PLANNING APPLICATION NO 2023/62/92230/W

Collingwood, 5A, Greenway, Honley, Holmfirth, HD9 6NQ

We wish to lodge our objection to the above application for the reasons given below, and respectfully request the Planning Authority to reject it after its own consideration:

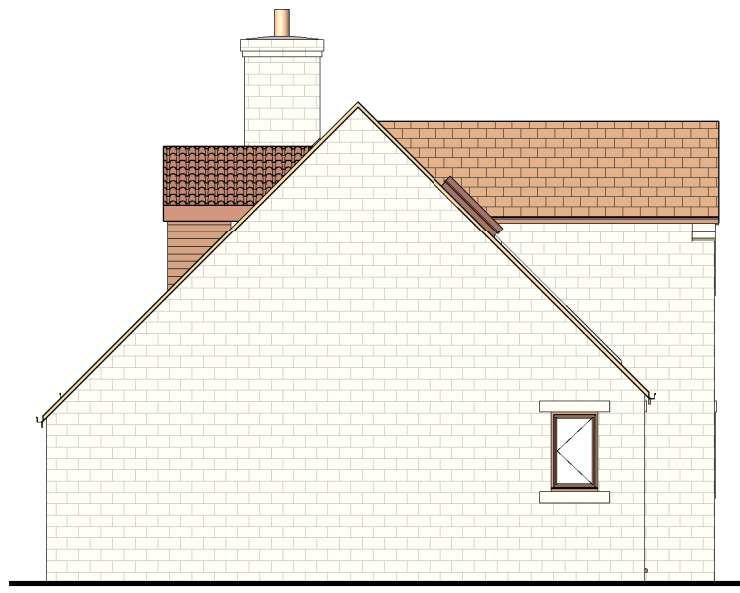
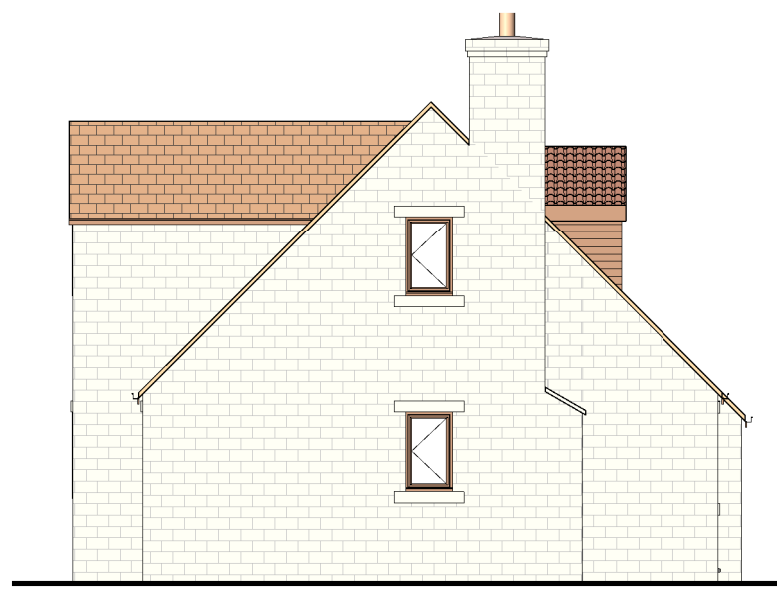
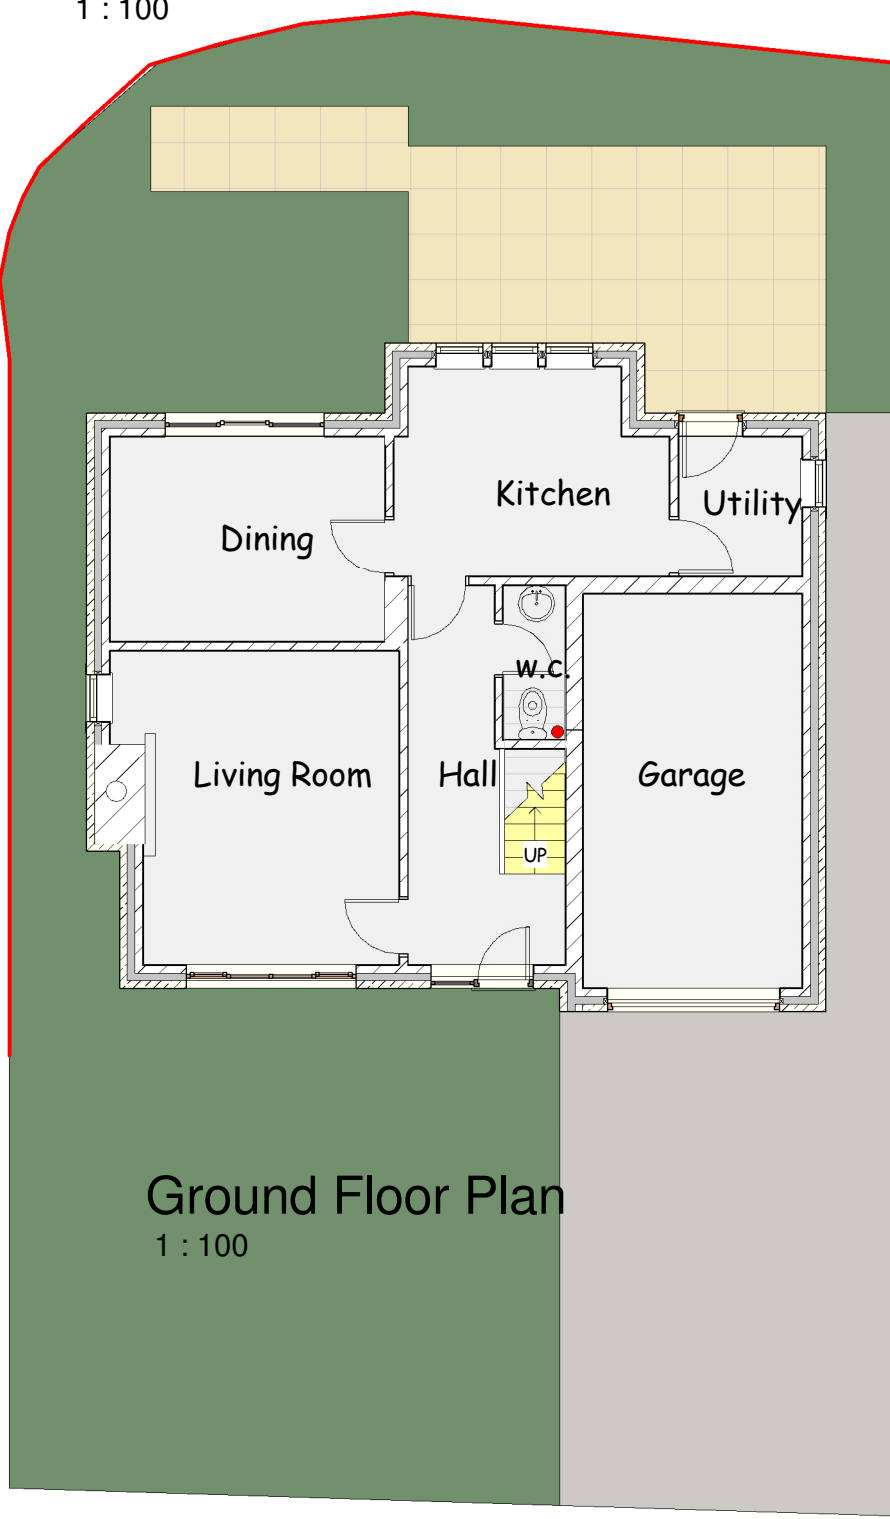
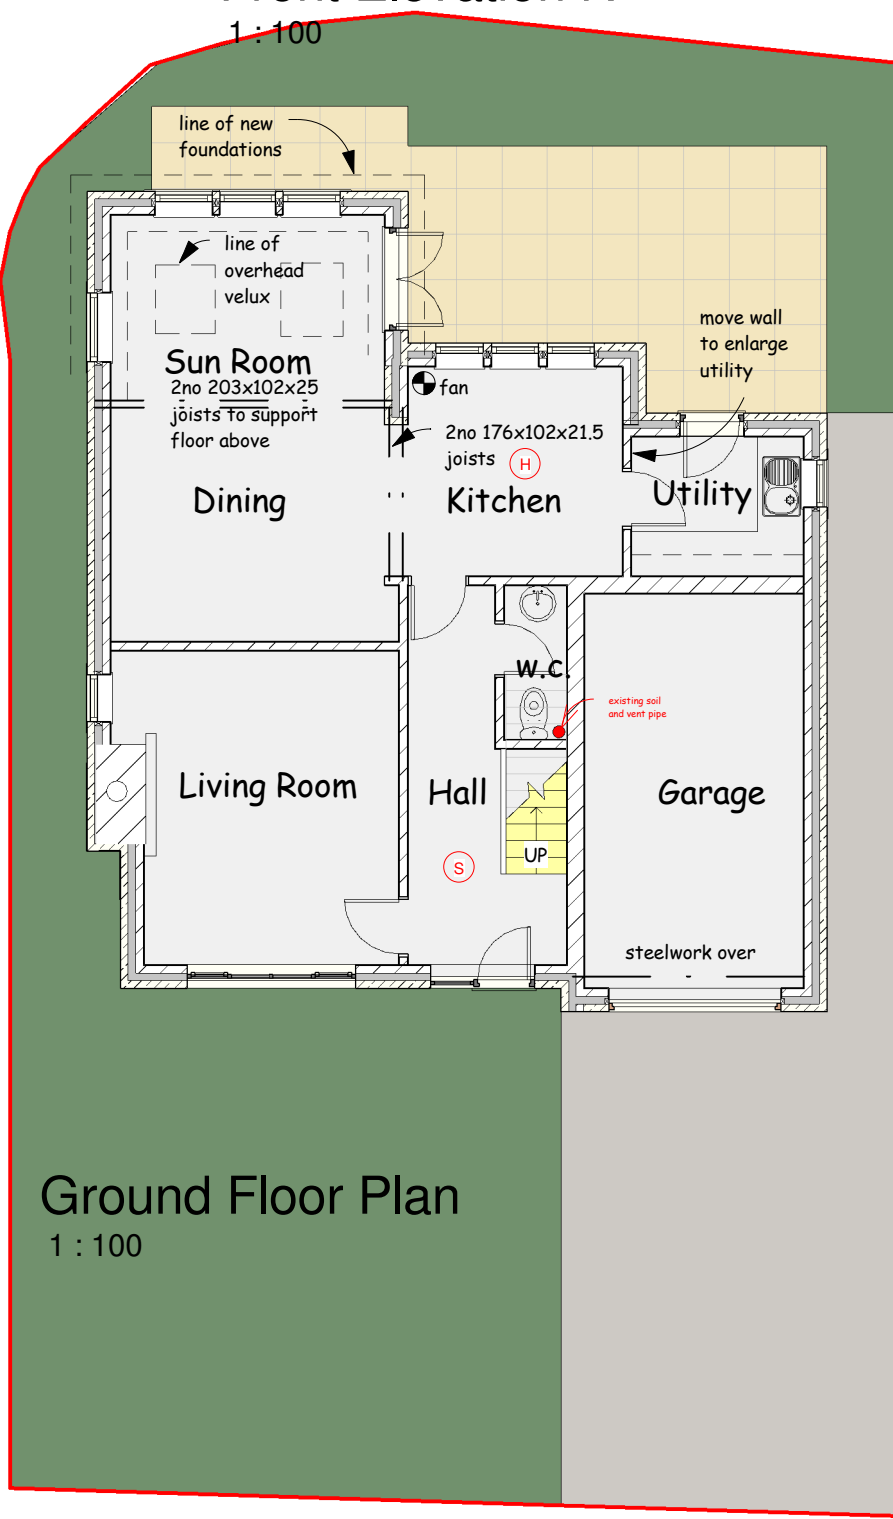
The photo below shows the house is at the top of a slight incline next to two bungalows. Squaring the roof line as proposed will change the appearance of the entrance to the Greenway estate.

The house occupies a similarly predominant position from the other side. The next door houses have a distinctive roof line which is repeated on others on the estate. Squaring off 5a would introduce a style not found elsewhere and create a building with significant bulk as a result of removing the three gable windows and flattening the front of the house and by

building an extension to the rear. Although perhaps not apparent from these photographs, the drive and back garden of 7 Greenway is already dominated by the side and back of this building, and would be overpowered by any additional height or width.

The proposed building will overlook neighbouring properties and eliminate the sense of spaciousness of Greenlea Court.

- Homes and buildings – *the proposed extension would be too close to the property boundaries, would be intrusive to neighbouring properties as a result of its size, shape and bulk and would overlook them. We cannot access any ground plans or measurements*
